**CBL: 052 H002001**  
**Located at: 144 WASHBURN AVE**

NOTICE OF VIOLATION

**Inspection Violations**

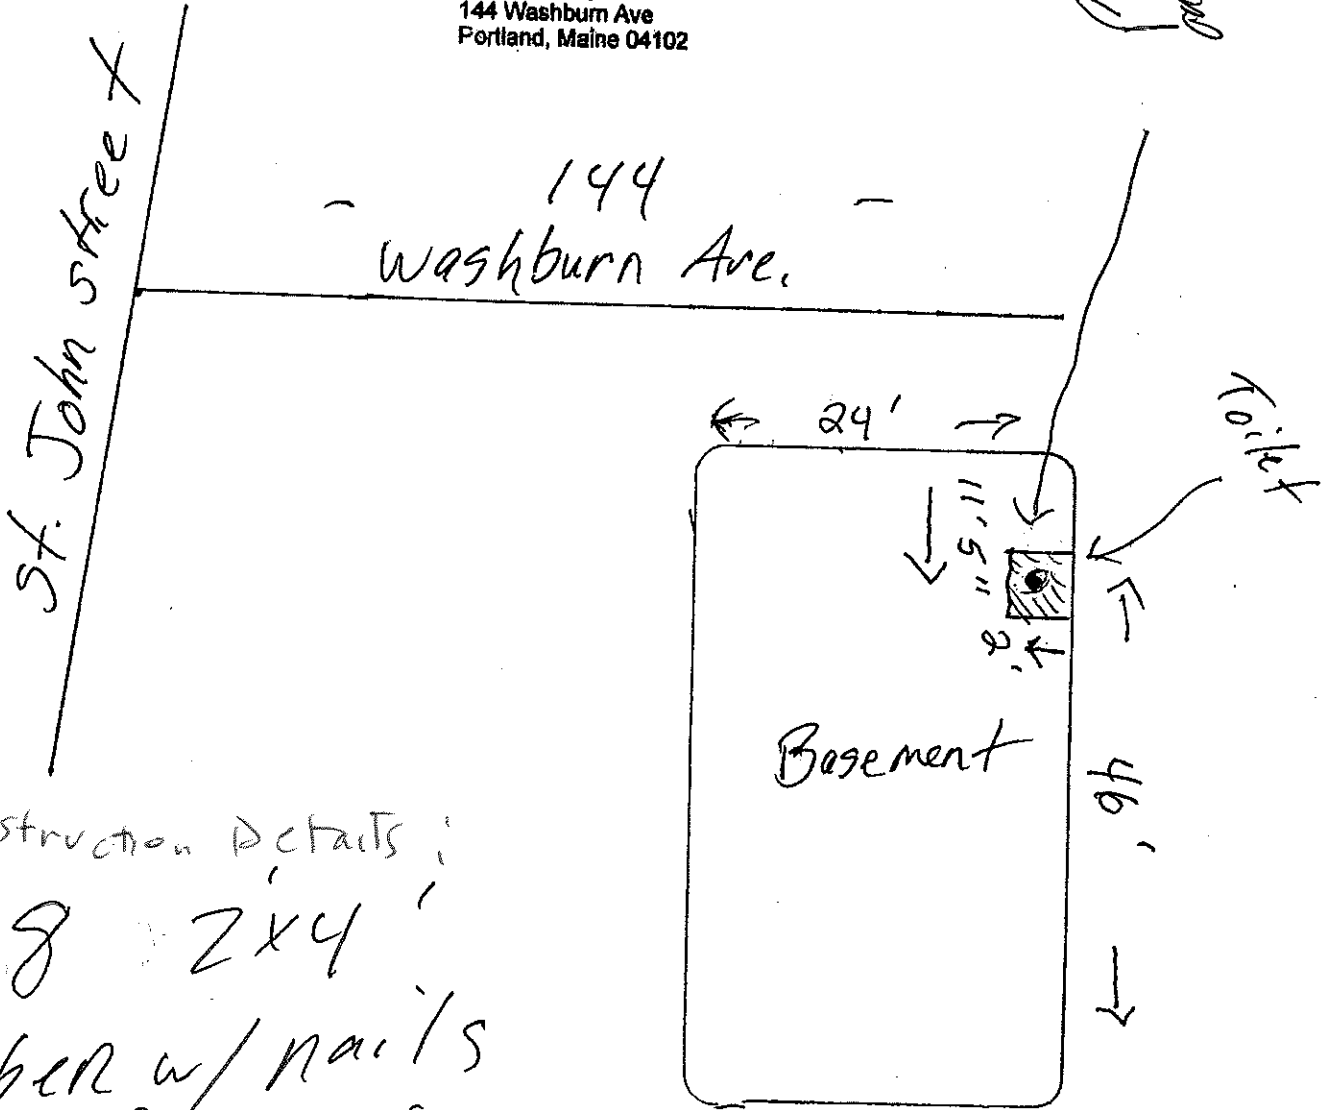
**Notes:** Apply for an after the fact building permit within 10 days for the toilet in basement or remove and cap off plumbing.

**Comments:** Basement had unpermitted toilet, needs to apply for after the fact building permit or cap it. Bedroom with no egress, bed needs to be removed.
